**Application** H16-0157-26  
**Location** Between Mortimer & Beaulor The Raceground Spalding PE11 3AP  
**Proposal** Erection of Bungalow - outline approval H16-1019-23

**Name** Cllr D R Ashby  
**Address** c/o South Holland District Council Council Offices Priory Road PE11 2XE

SITE PLAN

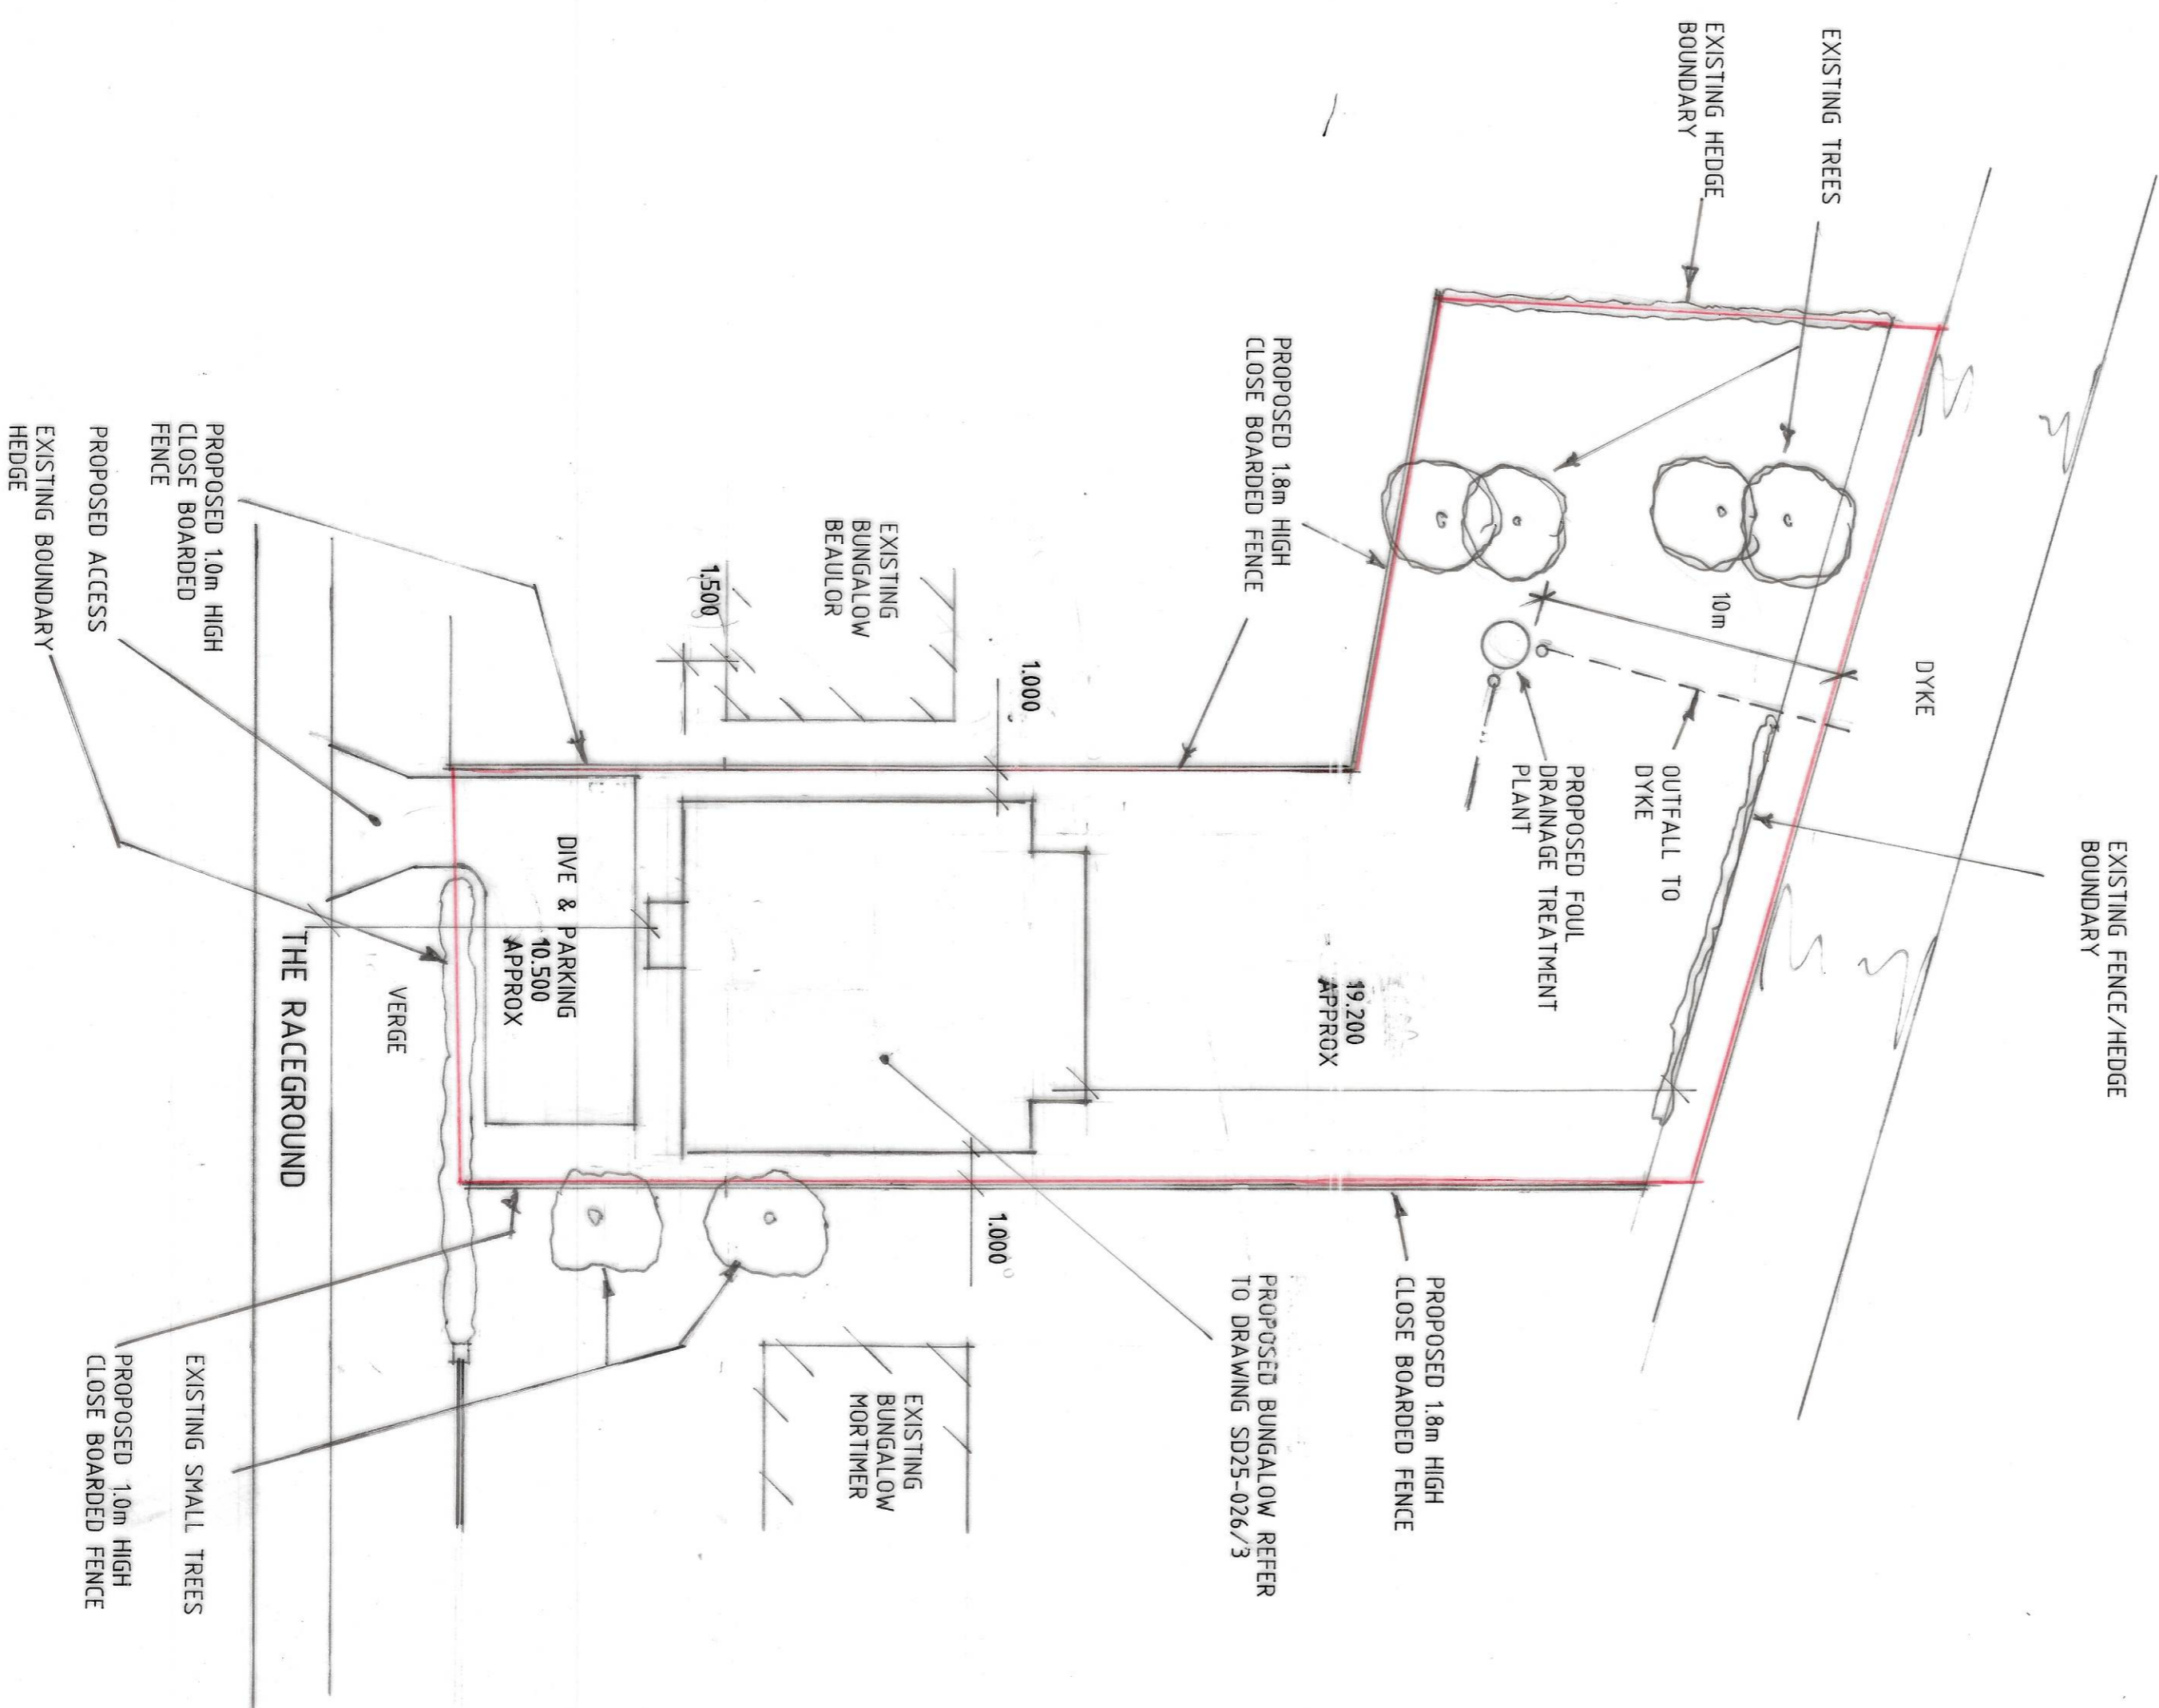
The size of this seems to big for this plot
